YorkshireWater

**Your Ref: 2025/1076  
Our Ref: B/00751**

**Bell Yard, Wells Street, Cudworth, Barnsley, S72 8DP – (BARN) – Erection of 5no. dwellings**

Drawing No.	Rev No.
MDW001 -001

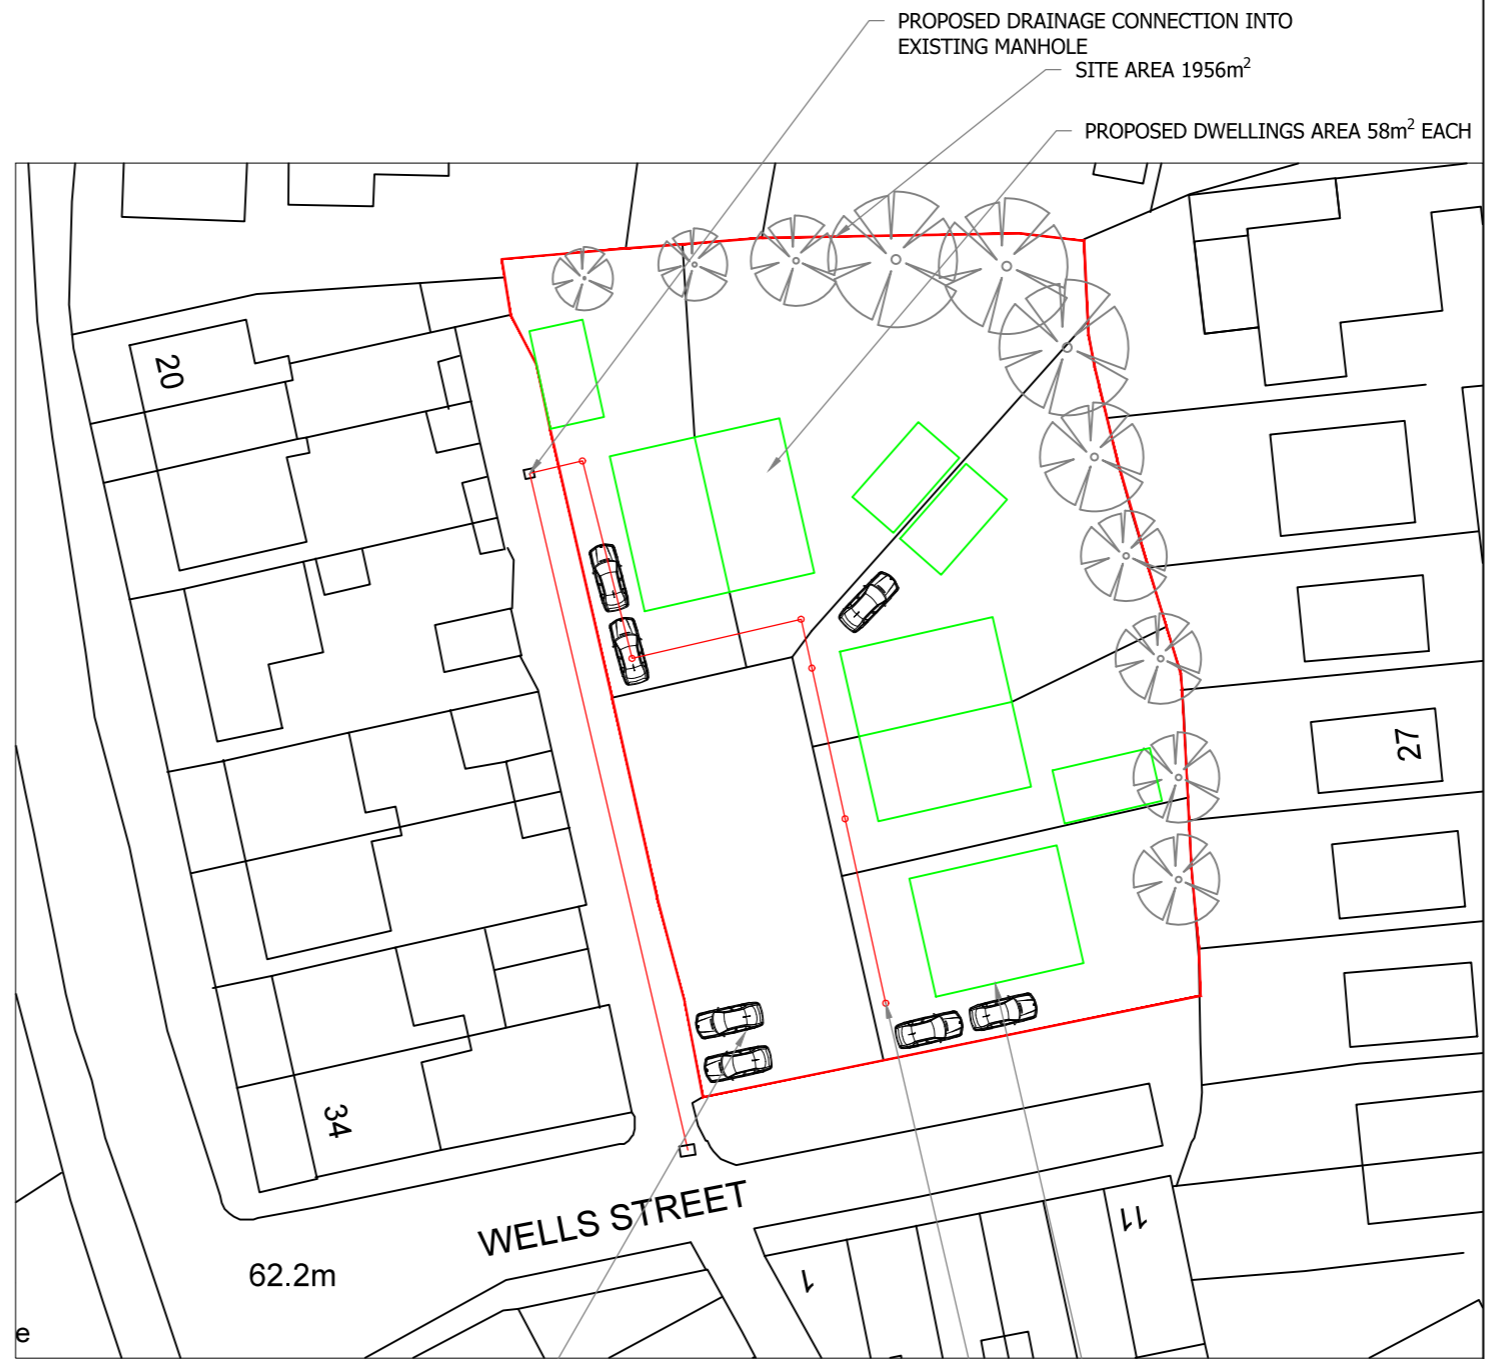
1.) It is noted from the submitted planning application that surface water is proposed to be drained to soakaway – Yorkshire Water fully endorse this means of surface water disposal.
